From: Terry Tunmore [REDACTED]
Sent: 05 April 2019 14:31
To: Anita Gardner
Cc: Debbie Tunmore
Subject: Conditions Discharge - 44 Tarrant Street, Arundel. AB/17/19 DOC

AB/17/19/DOC - 44 Tarrant Street, Arundel

I have received the comments of the Conservation officer in respect of the above application which are as follows:

Drawing No: FR1.1

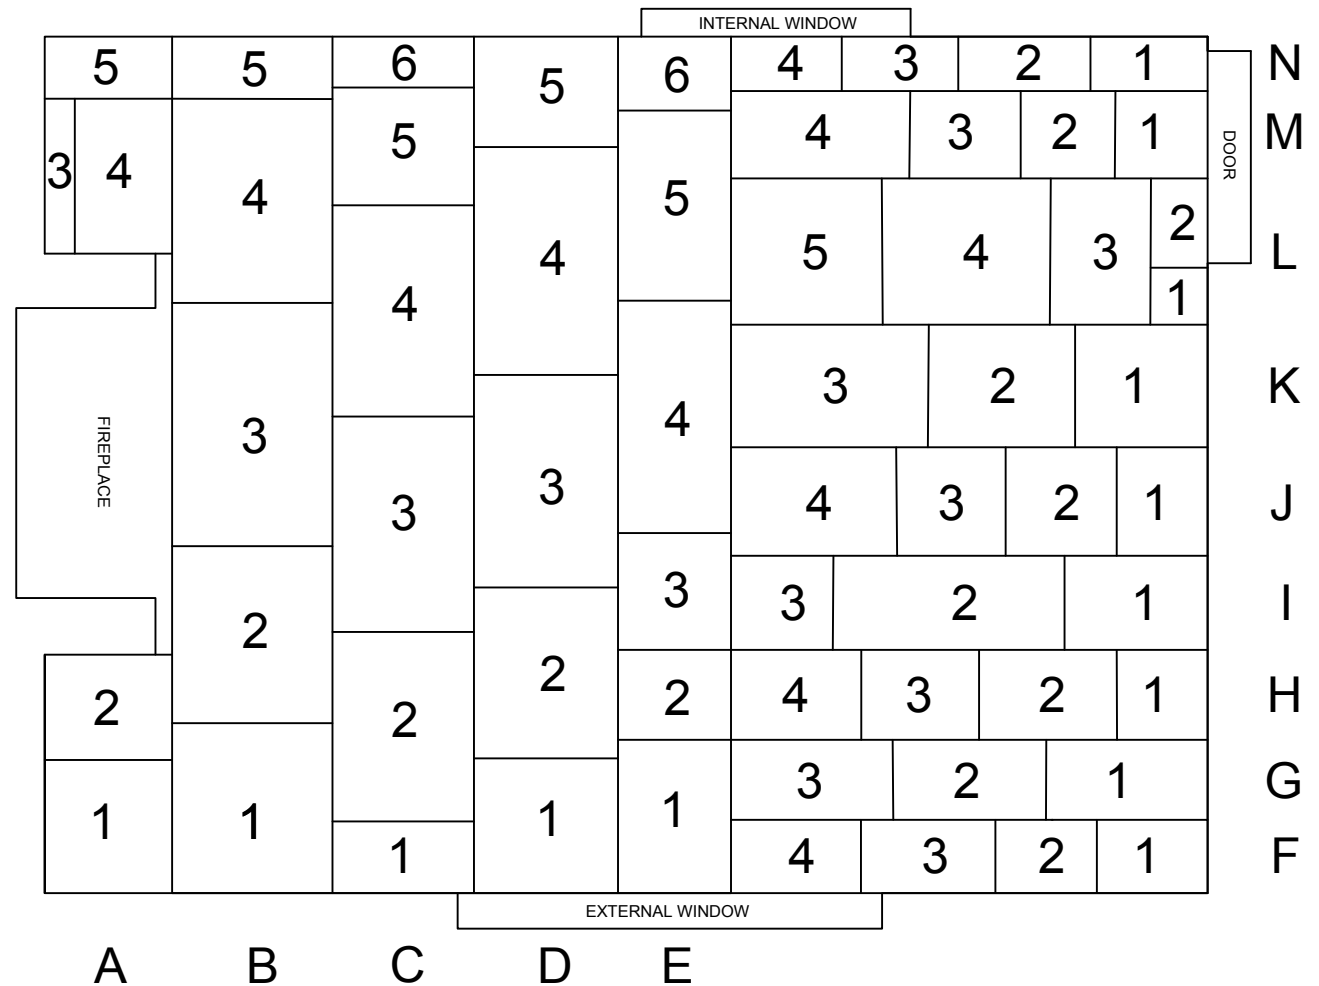
Detailed drawings have been provided for both the front basement room and the hallway. It is assumed that these have been provided to us following a survey? The drawings have been faithfully reproduced from a measured survey of B4 - Breakfast room and B5 - hallway. We have test lifted one stone and we are generally confident we can lift the stone successfully without breakages. The stone lifted was approx 50mm thick and laid on a rough sandy/soil mix so should not require cleaning underneath with the subsequent risk of damage. Pictures of the existing floor should also be provided for information. Pictures will follow showing stone and brick paver floors. The latter we have recorded laid pattern and direction for relaying. The close jointing of the stone and bricks is visible in the pictures, we will follow this format grouting the fine joints with a sand/lime mix. This appears to be as original but clearly years of dirt and debris have filled any joints.

The method statement for the York Stone flooring only goes as far as recording, removal and storage. Further information should be provided relating to the re-laying of the slabs. The Listed Building application and consent allows the reforming of the cellar floor with a new concrete sub base, damp proof membrane, insulation and screed being vital to maintain the ongoing integrity of the building. We propose laying the stone and bricks on a lime/cement/sand base directly to the screed simply to secure and to generally accommodate any unevenness to the underside of the stone. Reference is made to a photographic record of the floors, and it would be helpful to have a copy of this information. Photographic record to follow.

FIREPLACE SURROUND SCALE 1:20

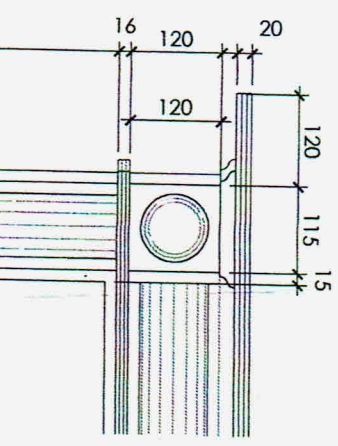
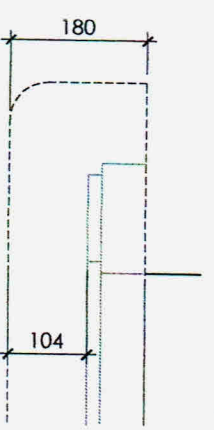
Rooms G2 and 3: The retention of the fireplace surround in room G2 is acceptable, as is the concept of replicating the fireplace in room G3. I note that a very small architectural drawing is included in the statement; an actual drawing should be provided so that the details can be confirmed. Room F3: The re-use of the existing surround in the master bedroom is acceptable. We have checked on your planning portal and unsure why our document reproduced in such a small scale. I will forward an A3 drawing which I believe was sent from our office originally.
